From: Thomas Darlington
Sent: 26 January 2023 07:40
To: Bob Sharples; Wayne Campbell
Cc: Andrew Earnshaw; Christina Cherry; neil.higginson@ecb.co.uk; Joseph Hall; 'JasonBowers@RFU.com'; 'Joanna Hawley'
Subject: RE: App Ref: 22/00747/OUT - Land at Bicester Road Kidlington - Sport England Ref: PA/22/SE/CL/61234

Thank you for reconsulting Sport England with additional information including a revised Design and Access statement and revised Development Framework Plan CSA/3263/123 Rev H.

Figure 4.3: Land Use Plan

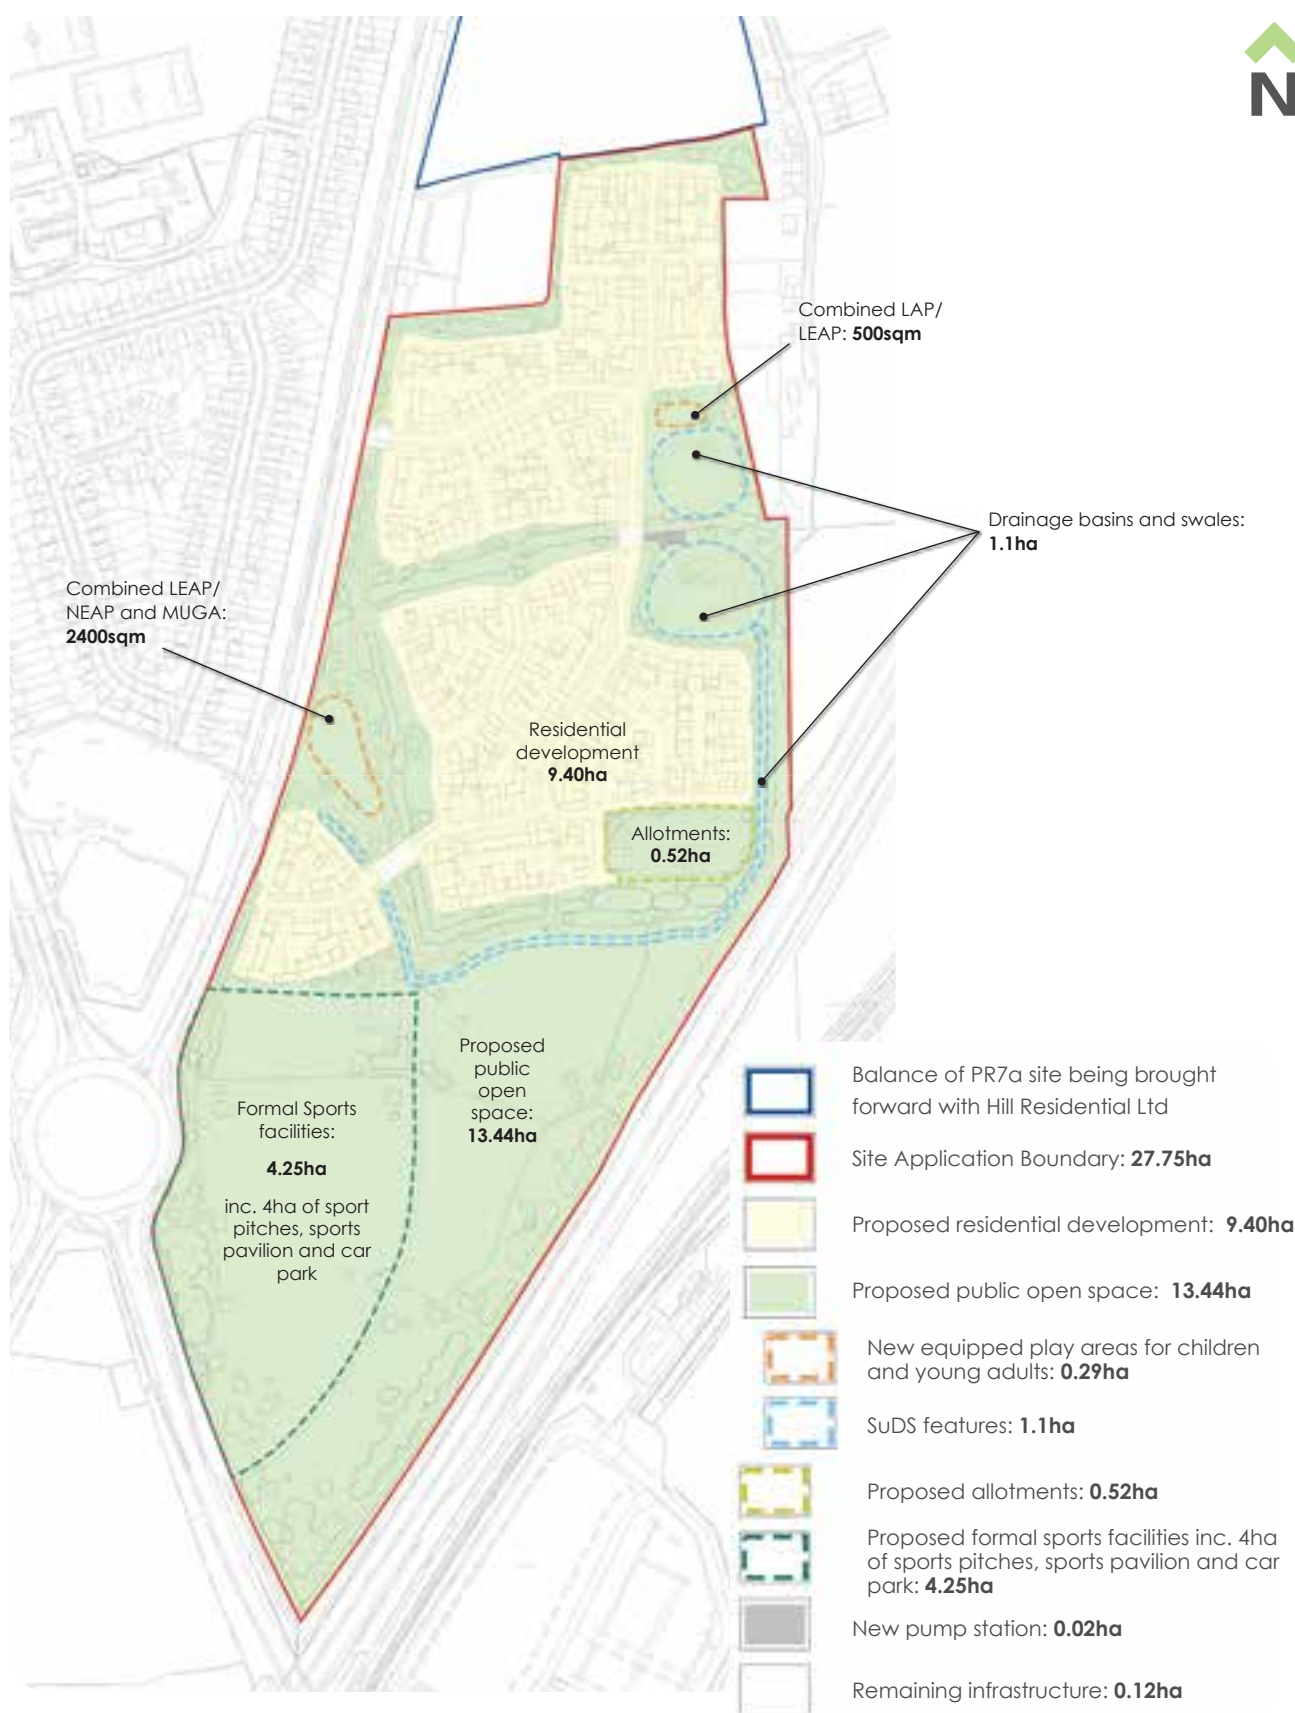
It is disappointing to see that both documents still do not give the same amount of proposed playing field. (para 4.3.5 in the D & A still gives it as 4.25 hectares and the plan 4 hectares! I note that in elsewhere in the D and A, it gives it as 4 hectares! In figure 4.3 the applicants are hedging their bets by quoting both figures 4 and 4.25.).

We are also concerned over the shape the allocated formal sports facilities which will make it difficult to rotate pitches as and when needed to reduce maintenance costs and deal with areas of the pitches wearing out.
